NSW RURAL FIRE SERVICE

Your reference: SSD-22191322-Mod-1
Our reference: DA20210530002237-EIS & DA
Exhibition-2

**State Significant Development – Hazardous Industry
Request for comments – exhibited Environmental Impact Statement (EIS)
2-18 Arlington Road KEMPS CREEK NSW, (none)**

From: [Alastair Patton](#)
To: [Kathryn Moreira](#)
Cc: [Simon Derevnin](#); [Nika Fomin](#)
Subject: FW: Oakdale West Stage 5 - Mod 1 (SSD-22191322) - Advice on Modification Report
Date: Monday, 27 June 2022 4:32:48 PM
Attachments: [image001.png](#)
[image002.png](#)
[image003.png](#)
[image004.png](#)
[image005.png](#)
[image006.png](#)
[image007.png](#)
[DA20210530002237-EIS & DA Exhibition-1 - 30-08-2021 22 27 58 - Determination Letter.pdf](#)

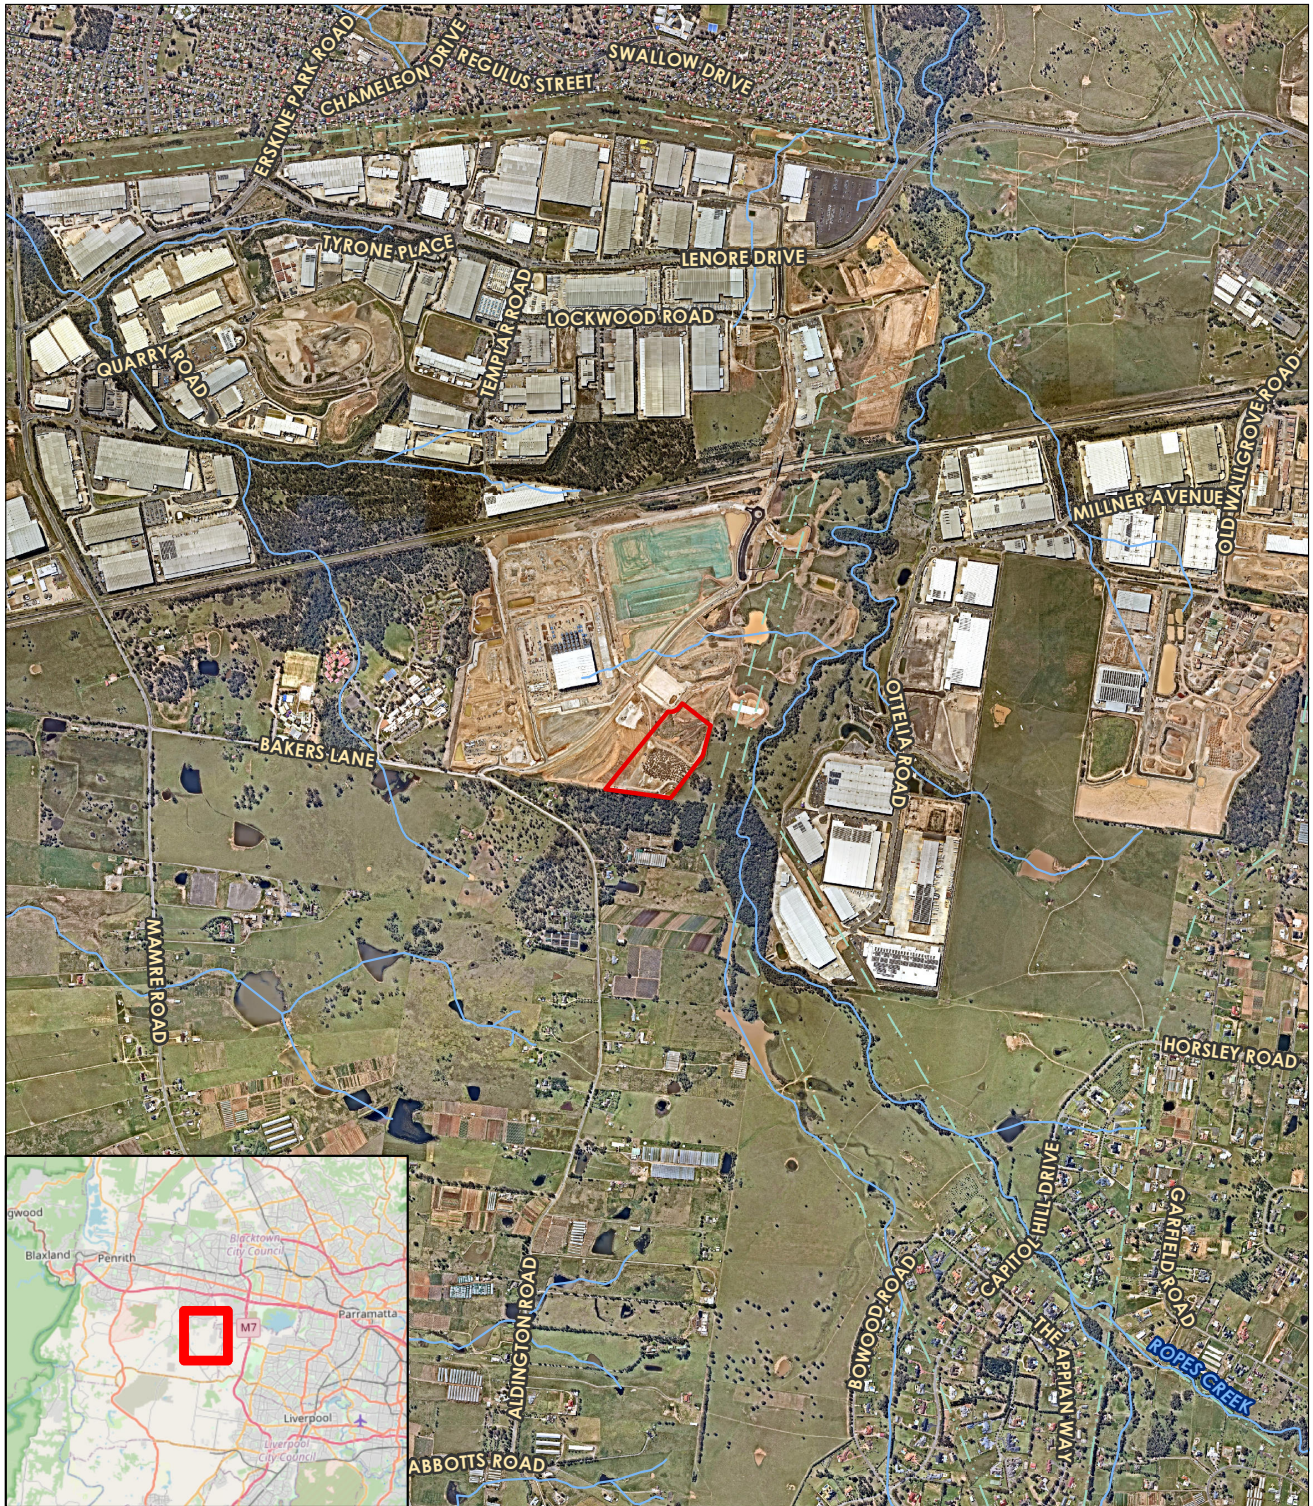
5. New construction must comply with the corresponding Bushfire Attack Level (BAL) as shown in Figure 3 of the bush fire report prepared Blackash Bushfire Consulting, dated 24 June 2021. The BAL must comply with corresponding sections of the Australian Standard AS3959-2018 *Construction of buildings in bush fire-prone areas* or NASH Standard (1.7.14 updated) *National Standard Steel Framed Construction in Bushfire Areas – 2014* as appropriate, and Section 7.5 of *Planning for Bush Fire Protection 2019*.

**Figure 6: Asset Protection Zones**

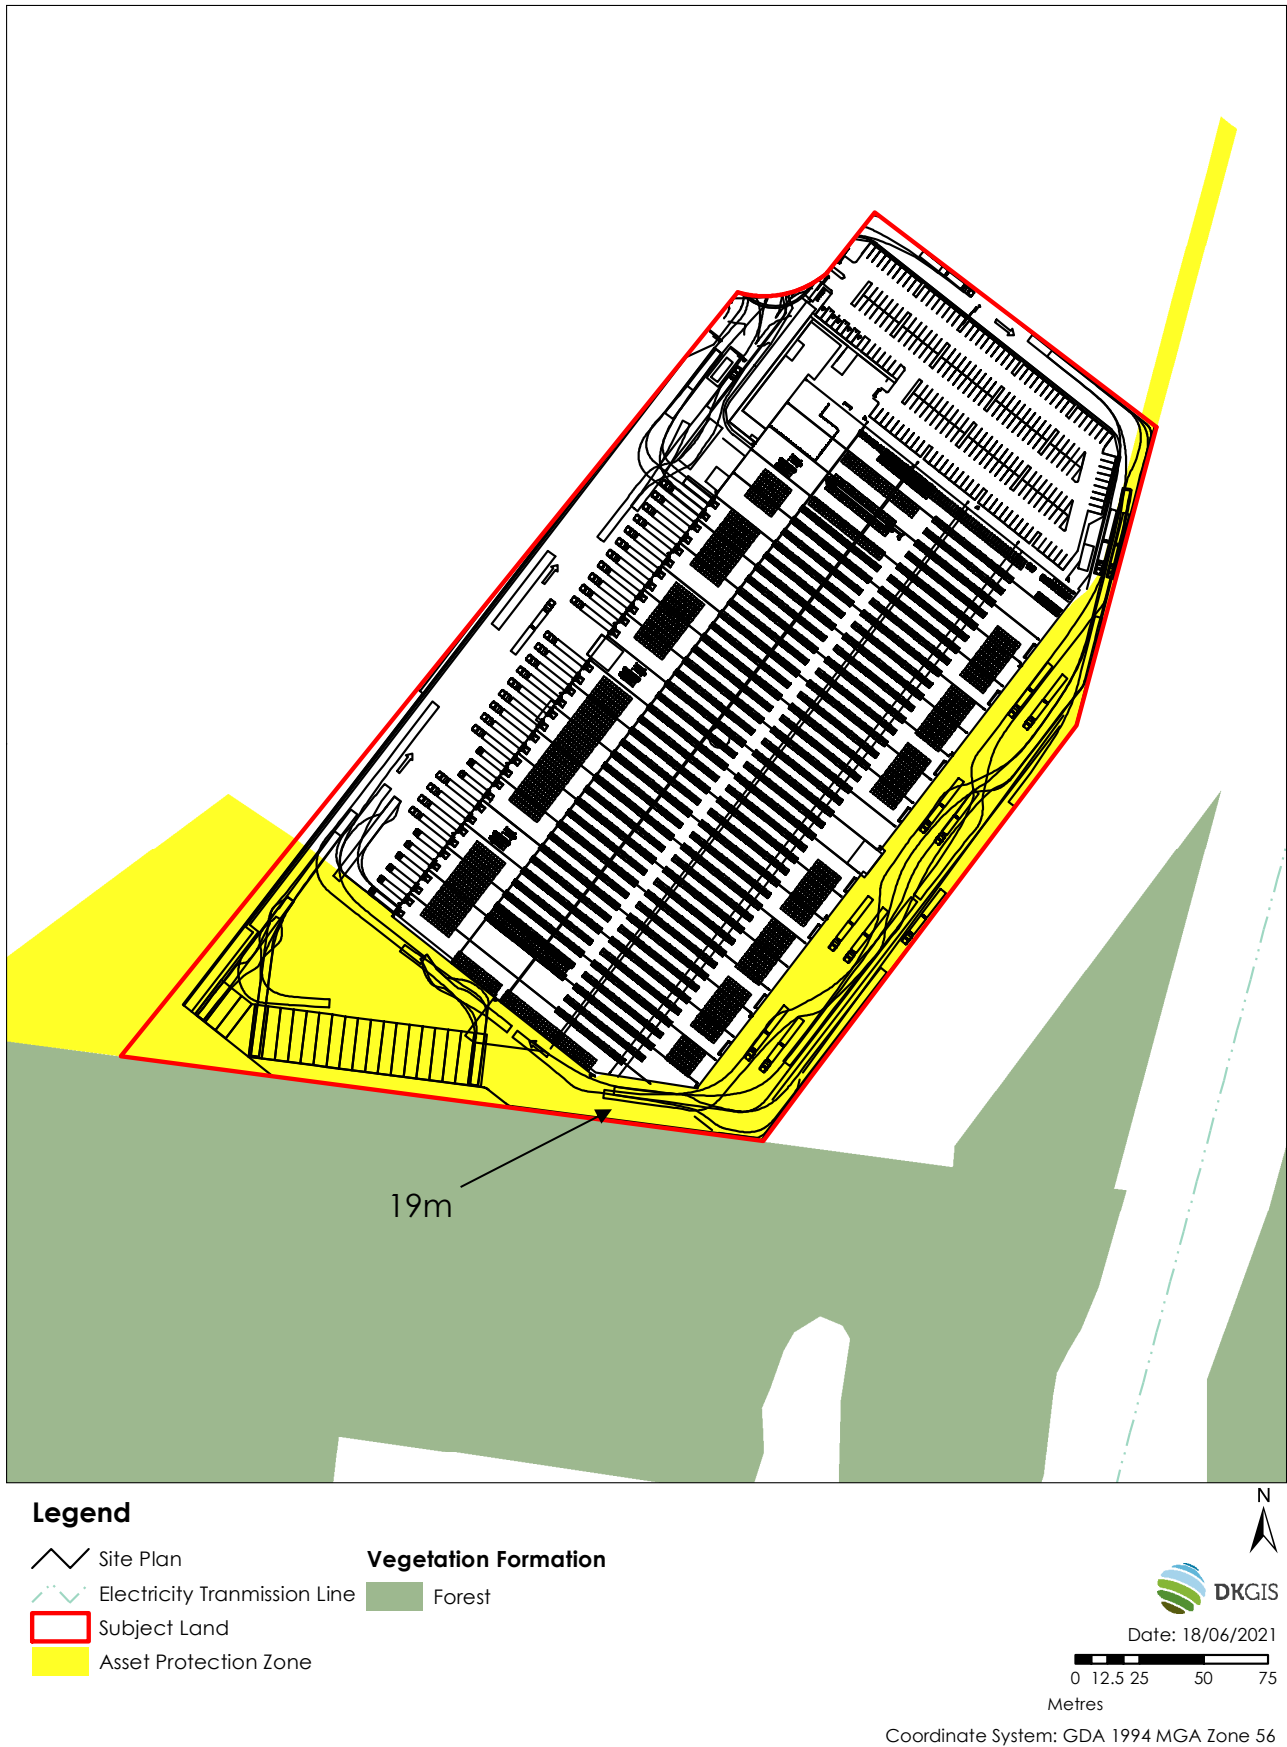
3. From the start of building works and in perpetuity, the entire subject development site must be managed as an inner protection area (IPA) in accordance with the requirements of Appendix 4 of *Planning for Bush Fire Protection 2019*. When establishing and maintaining an IPA, the following requirements apply:
